WEST SUSSEX COUNTY COUNCIL CONSULTATION

TO:	Arun District Council FAO: Simon Davis
FROM:	WSCC - Highways Authority
DATE:	31 May 2022
LOCATION:	Land adjacent to Wayside, Eastergate Lane, Eastergate, PO20 3SJ
SUBJECT:	BN/68/22/PL Erection of 4 x 4 bedroom houses. This application is a Departure from the Development Plan and is in CIL Zone 3 and is CIL Liable as new dwellings.
DATE OF SITE VISIT:	N/A
RECOMMENDATION:	Advice
S106 CONTRIBUTION TOTAL:	N/A

Drawing No.	2021-6378-001	Rev.	B
-------------	---------------	------	---

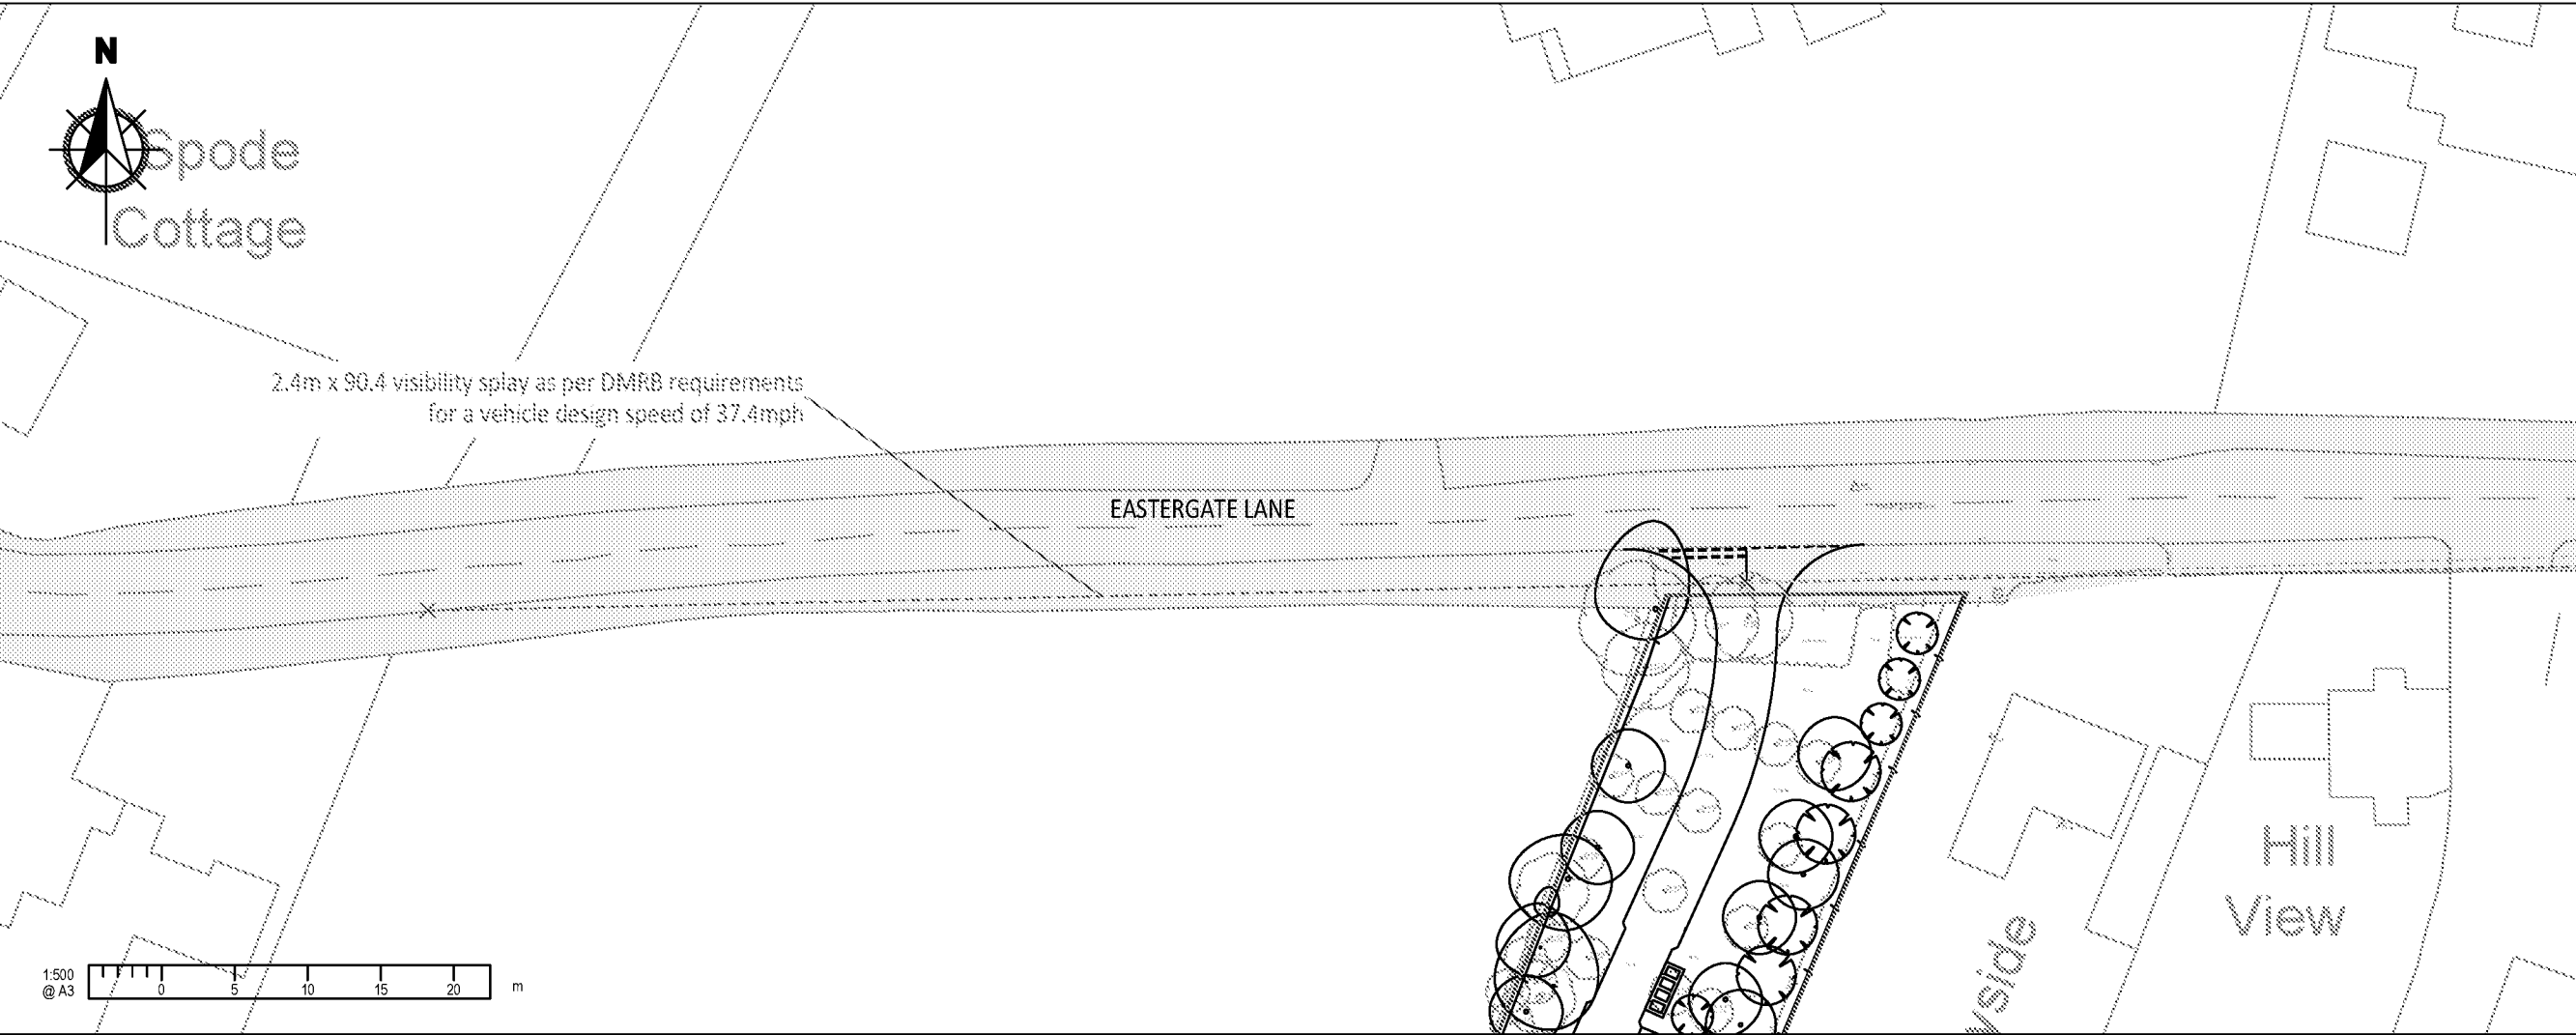
The applicant proposes a new bellmouth access on Eastergate Lane to serve the development. Visibility splays of 2.4m x 90.4m to the west and 2.4m x 100.5m to the east have been demonstrated for the proposed access. The demonstrated visibility is in accordance with DMRB guidelines using 85th percentile speeds ascertained from an ATC in this location.
